## **Fw: 23 Lower Unwin Street, Penistone, Sheffield, S36 6LX - Sewerage H4 Consultation on P462965**

23 Lower Unwin Street, Penistone, Sheffield, S36 6LX - Sewerage H4  
Consultation on P462965

SITE LAYOUT

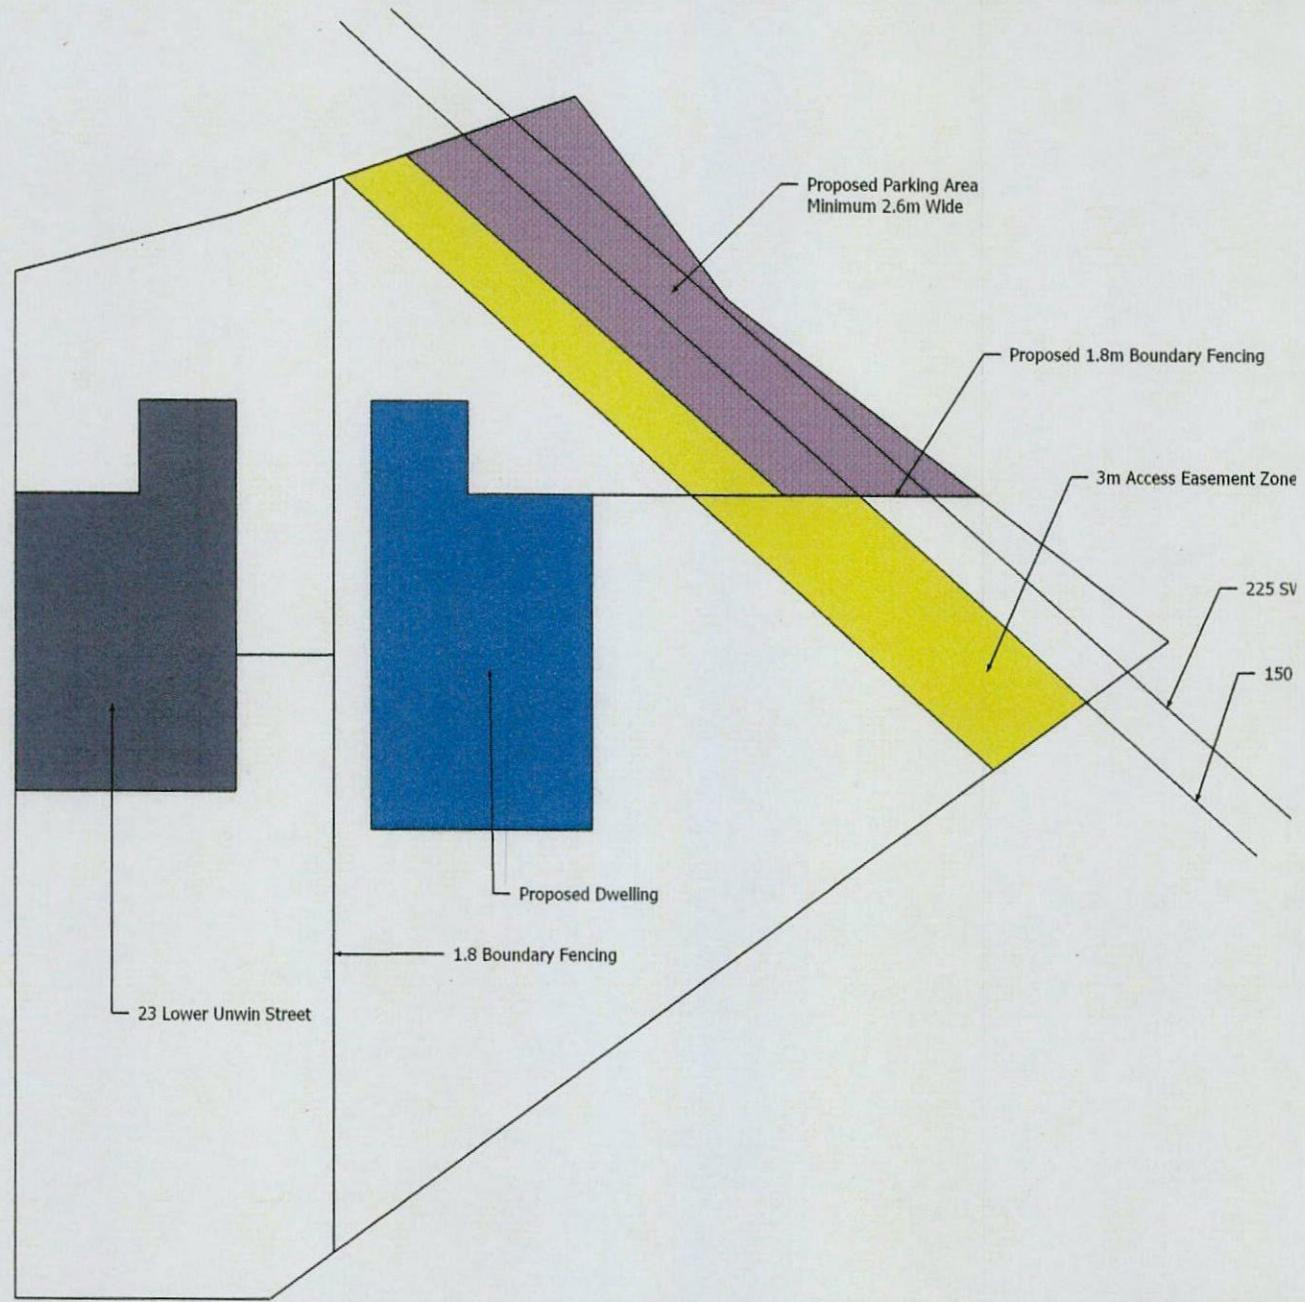
On the Statutory Sewer Map there is a drain, sewer or disposal main (a pipe) recorded where, or within 3 (three) metres of where you have

An access point is recorded on the pipeline. This may be a manhole or inspection chamber for example. Building over an access point is not permitted.

In this instance, Yorkshire Water would raise no objection in principle to the proposals as shown on your enquiry. This matter should subsequently be controlled by the Building Inspector under Requirement H4 of the Building Regulations. This is subject to, amongst other things, the following important matters:

There should be no public access points ie manholes, gullies, buried connections etc built over as part of the proposals.

The pipeline should be protected at all times. This is to prevent damage from occurring during and after the works. Heavy materials, for example, should not be stored over the pipeline.

The foundations should be designed and constructed so that no additional loading is placed on to the pipeline.

Where the pipeline is to pass through foundation walls etc. the wall should adequately span the pipeline.
